**RE: The Park Danforth
777 Stevens Avenue
Amended Site Plan and Subdivision Review**

On behalf of "The Park Danforth", we are pleased to submit the following Amended Site Plan and Subdivision Application for the proposed expansion of "The Park Danforth" located at 777 Stevens Avenue in Portland. The Park Danforth is requesting to construct three (3) additional one bedroom dwelling units on the fifth floor along the Arbor Street frontage. Since the planning board approval on February 10, 2015, detailed architectural plans have been developed and construction cost of the new addition and site improvements have been refined. It has been determined that providing the three (3) additional units significantly improves the financial success of the project. That being said, there have also been some value engineered building elements that have been identified as future construction. The modifications are further defined below.

Title: EROSION AND SEDIMENT CONTROL PLAN

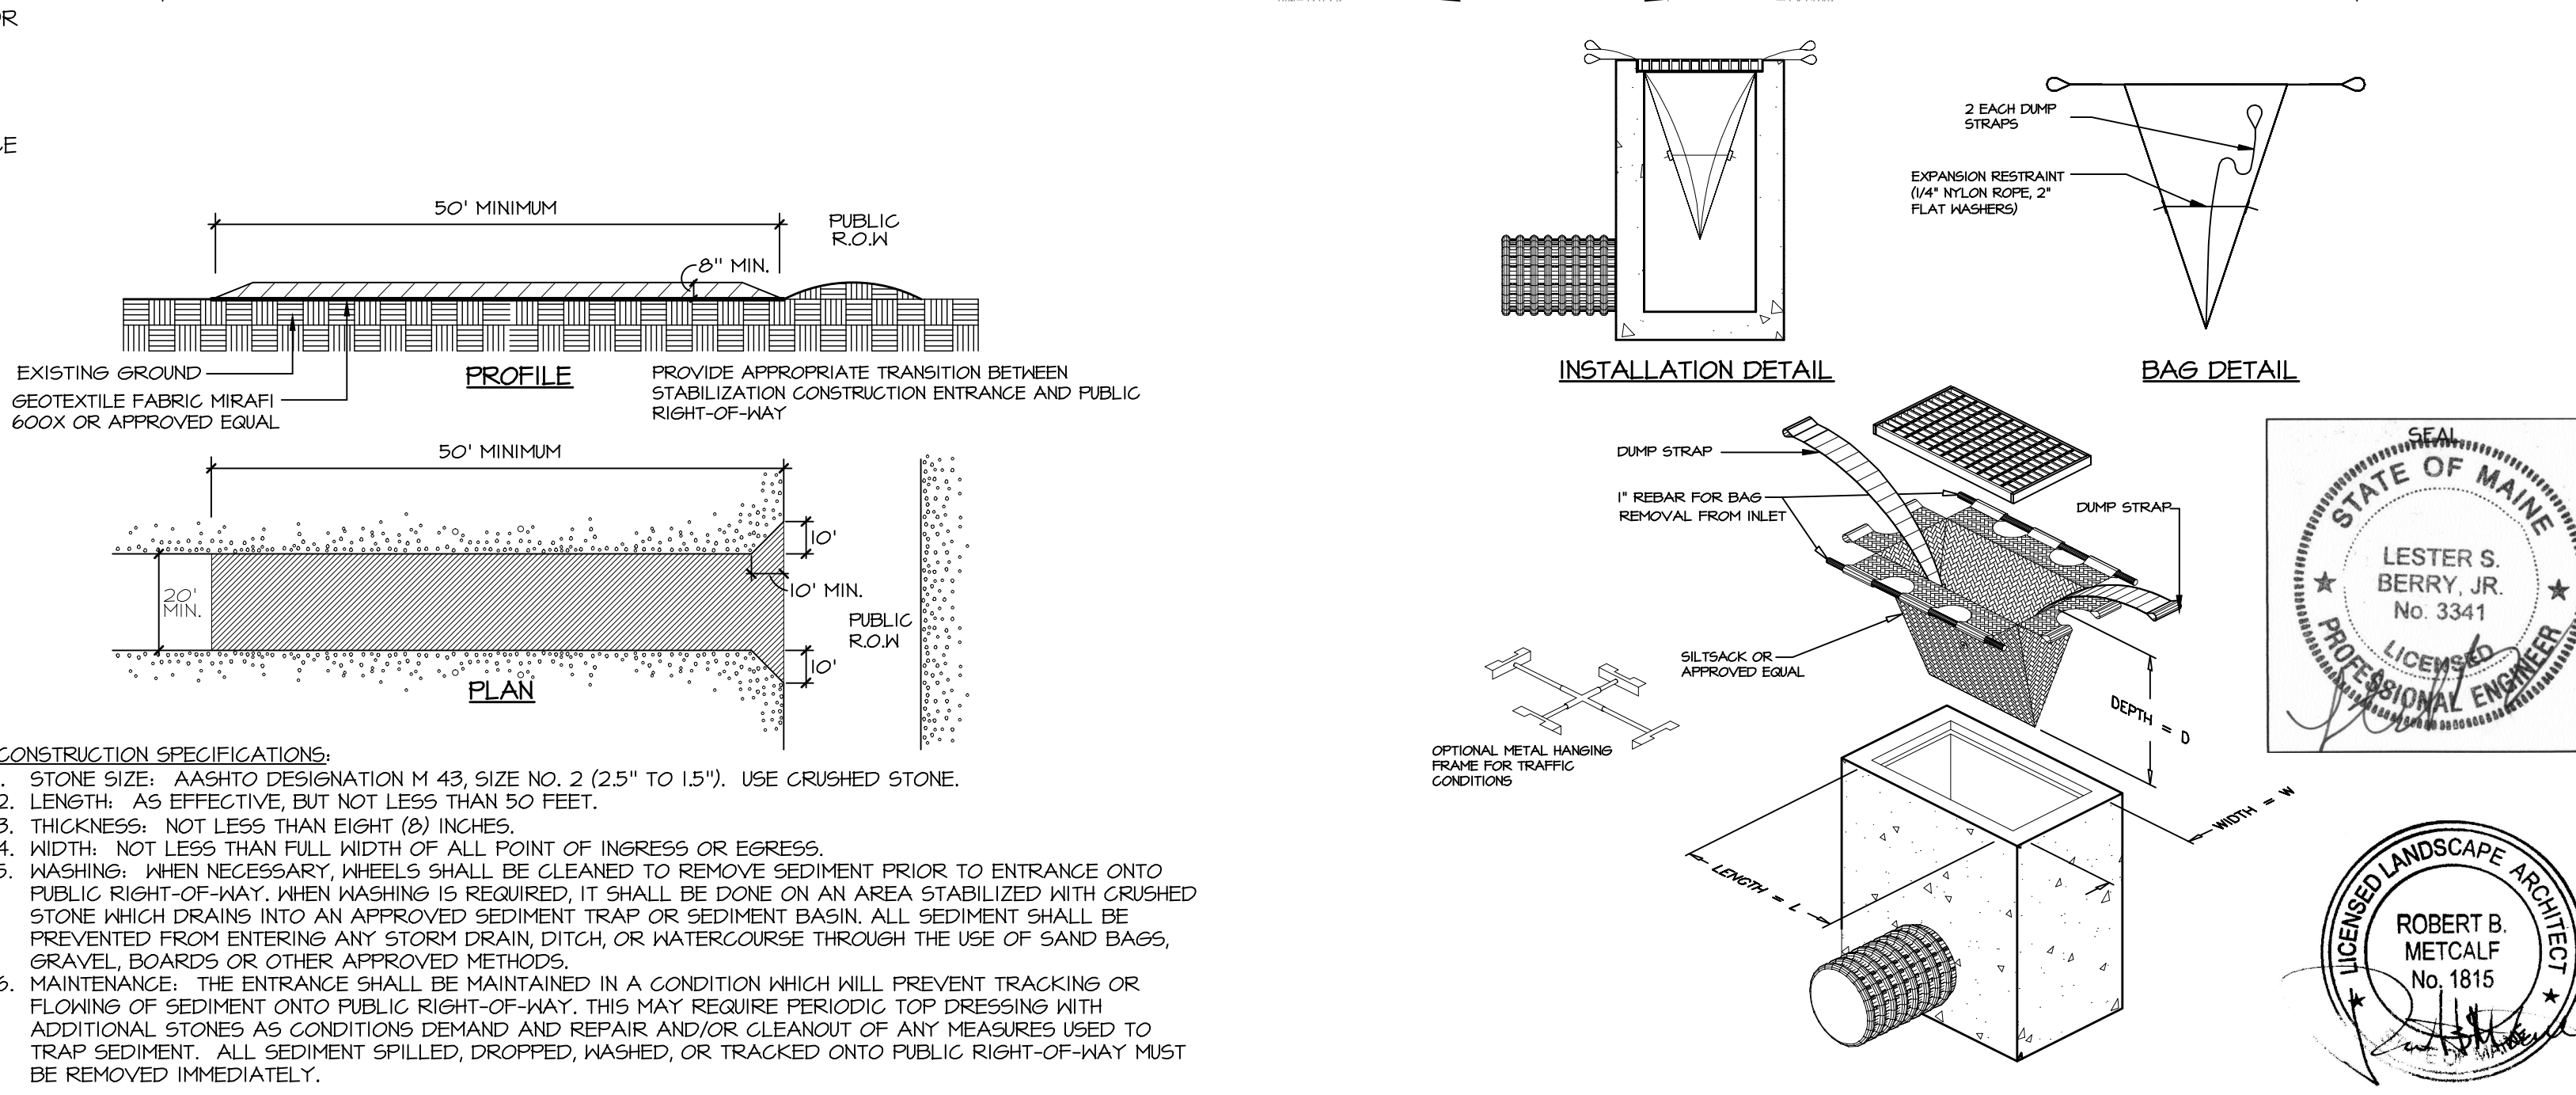
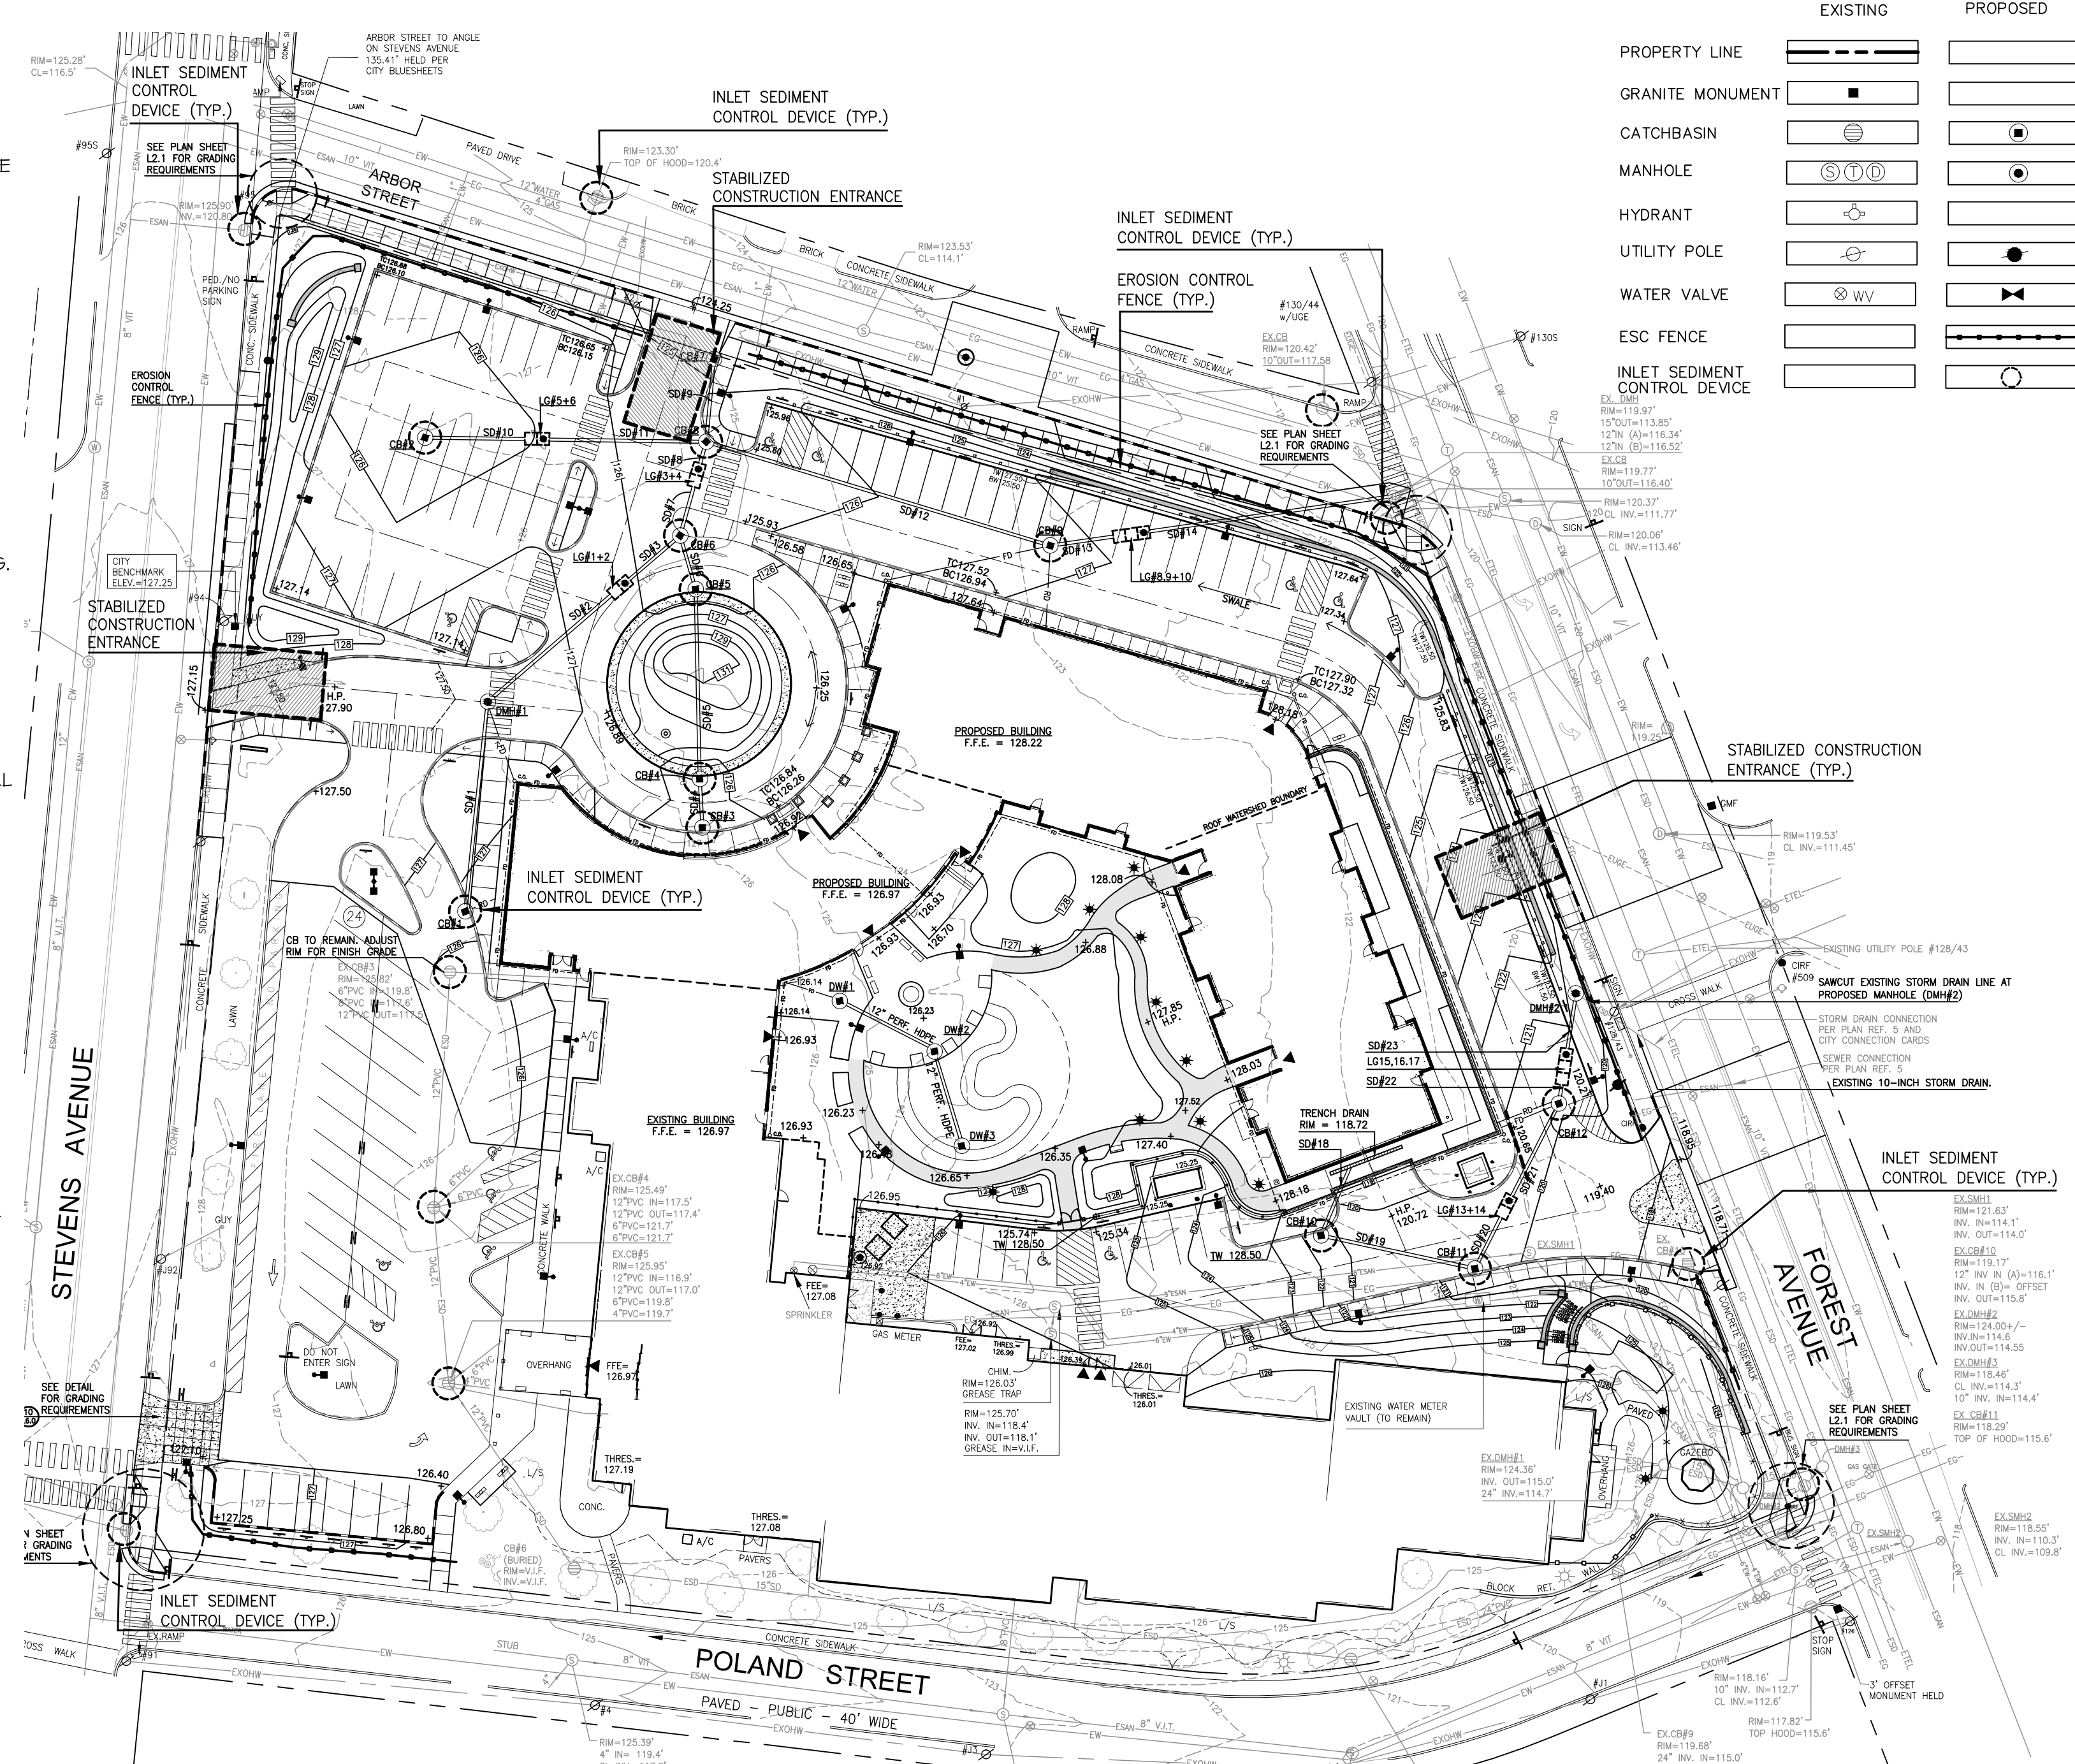
3. Stormwater Management review comments, provided by David Senus, have been addressed and changes made to the plans and details. The MDEP-Stormwater PBR will be provided to the planning staff at a later date.

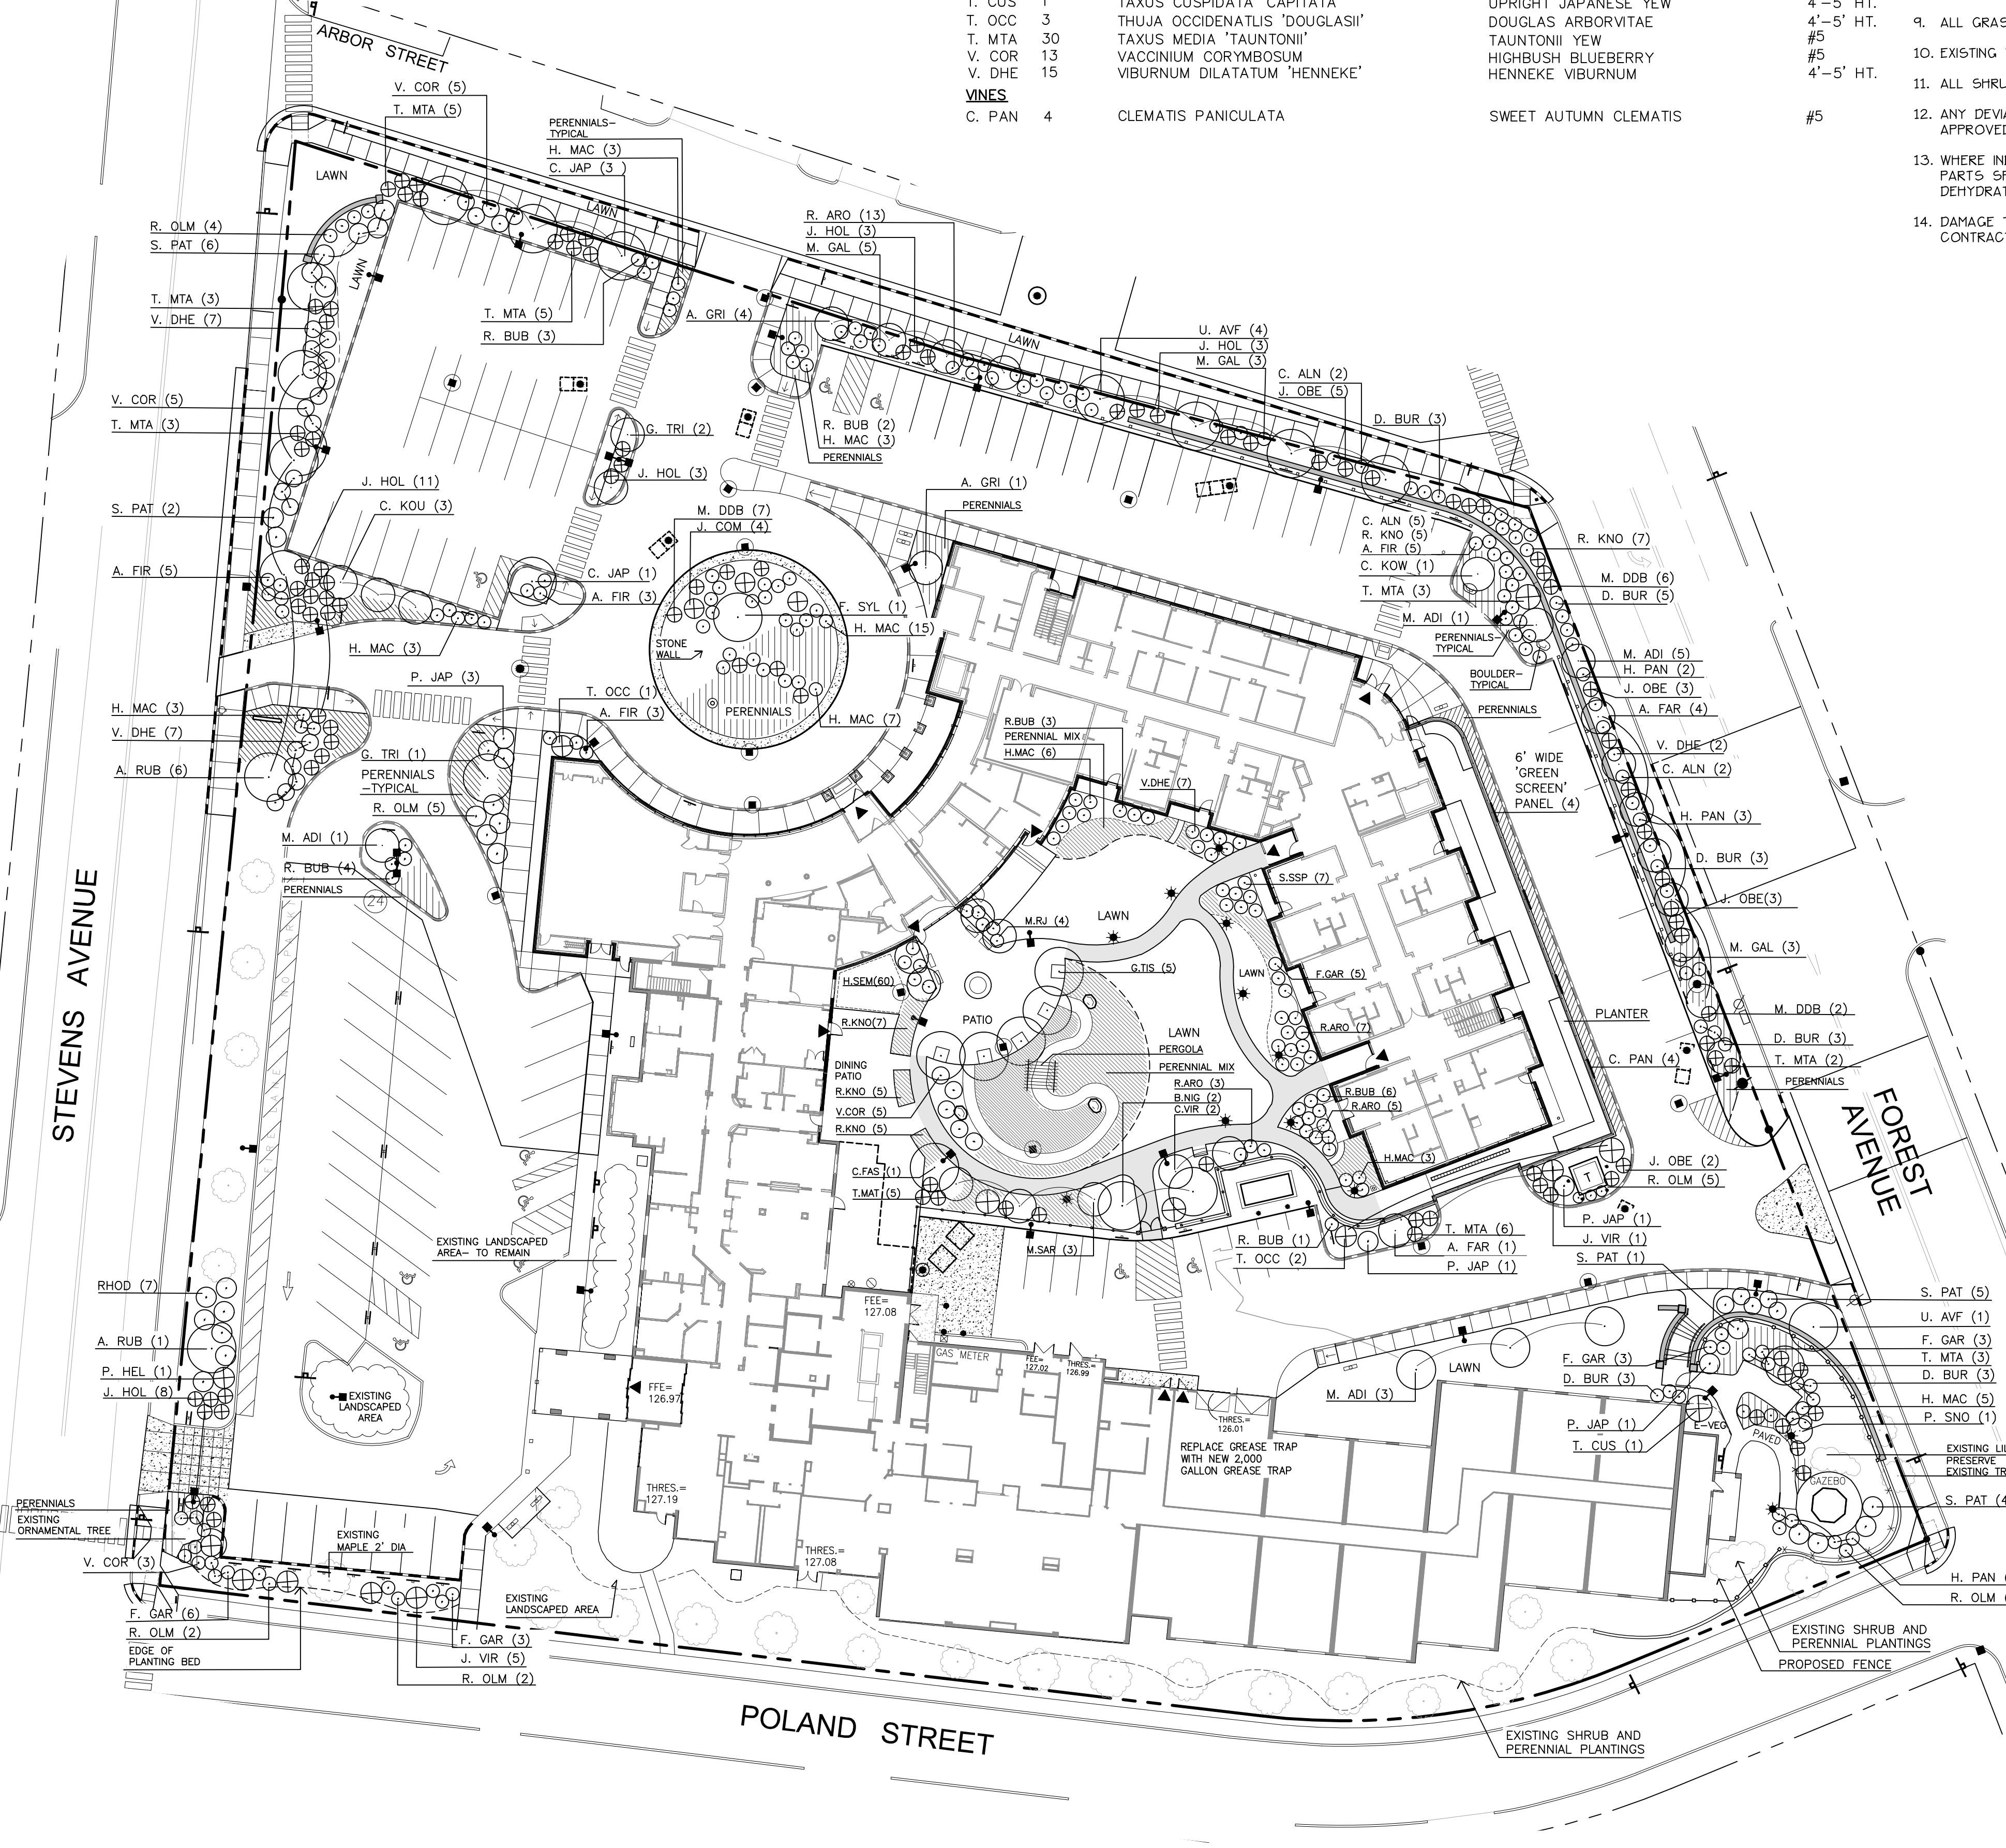
2. The landscape plan has been revised to address Jeff Tarling's comments concerning buffering along the perimeter and interior areas of the parking. Regarding the center garden court yard, the plan has been revised to respond to planting material and design comments. Modifications to the plan also include changing the six (6) foot sidewalk paving to bituminous paving and changing the gazebo to a small pergola. As discussed during the initial approval process, The Park Danforth would like to incorporate more amenities to the courtyard. However, due to budget constraints the proposed improvements as shown are to be constructed. Should additional funding become available, additional improvements will be implemented.
